Our Ref: BE/19/20/DOC

**Approval of details reserred by condition imposed under ref BE/84/19/PL relating to Condition No 4 -
Construction Enviromental Management Plan**

Site 6 Chichester Road North Bersted

DRG No. S783-6-SSP-4C	REV. B
--------------------------	-----------

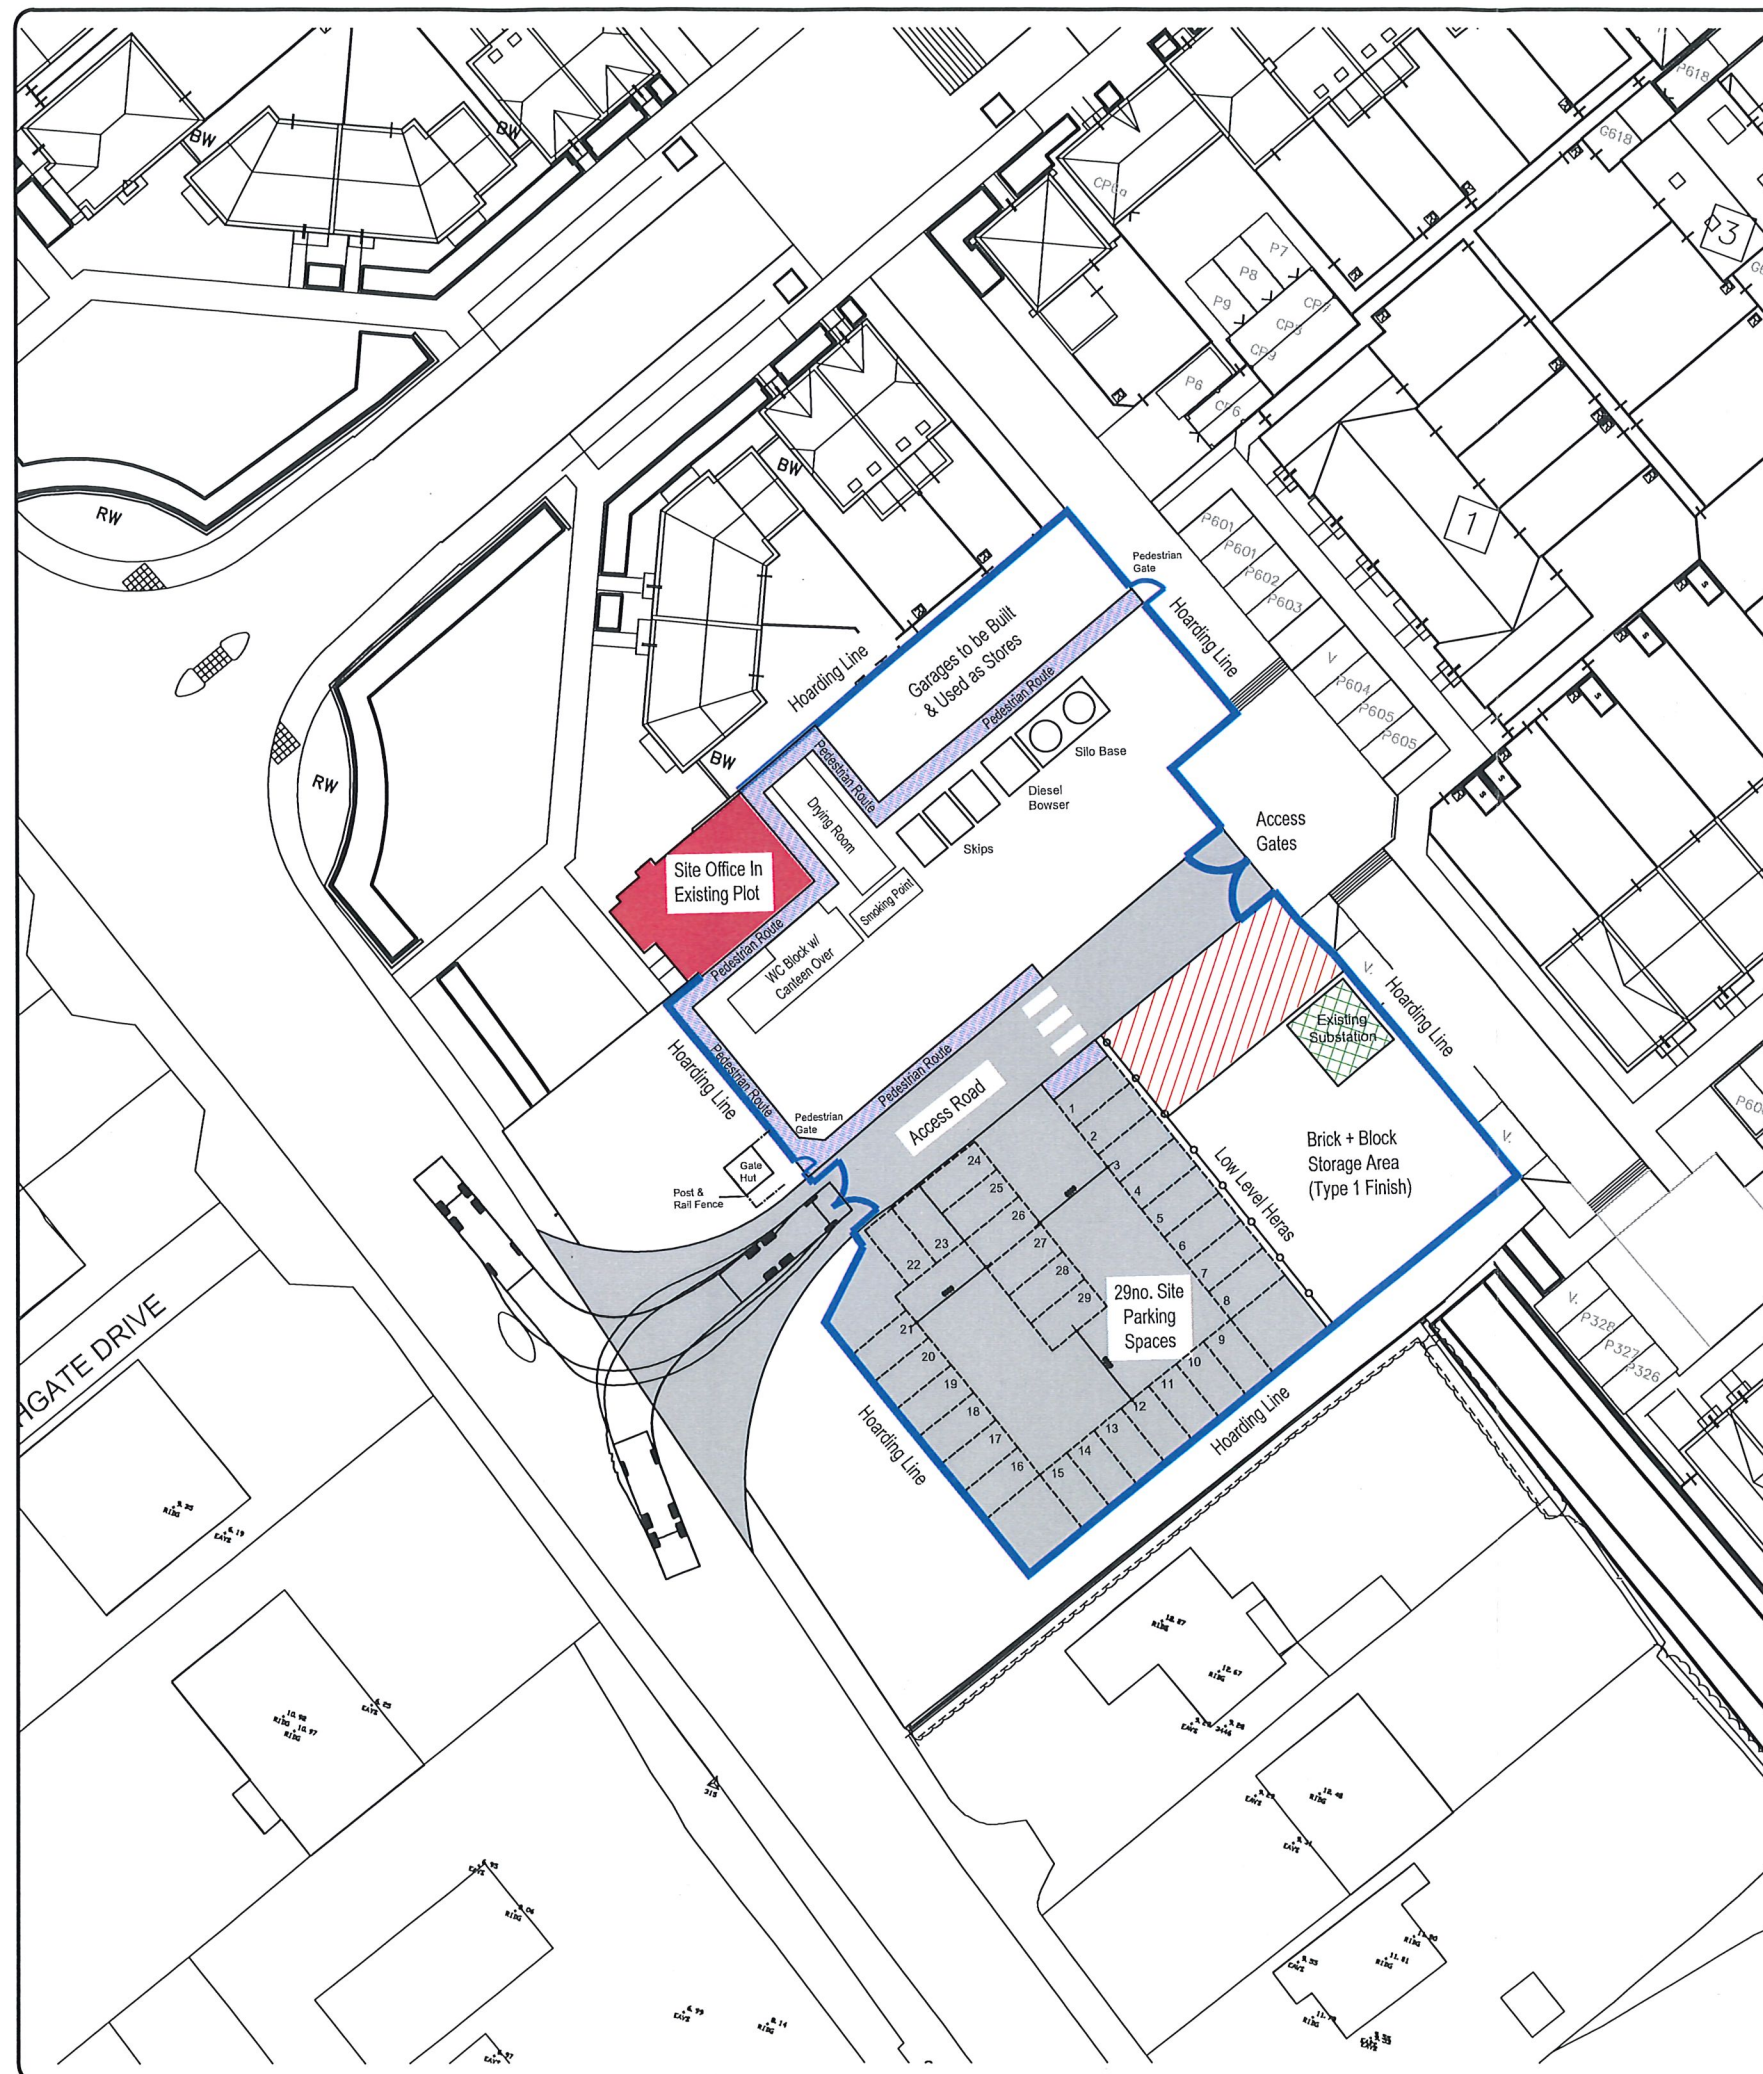
It has been clarified that there is an in/out system for deliveries the applicant should be satisfied that HGVs can manoeuvre through this route with the hoarding as it is. The commitment to carry out wheel wash if required is noted and thus the plans and details pertaining to condition 4 are acceptable.

This condition is discharged in so far as submission of details relates and refers to the plans submitted with this application: S783-6-SSP-4C.
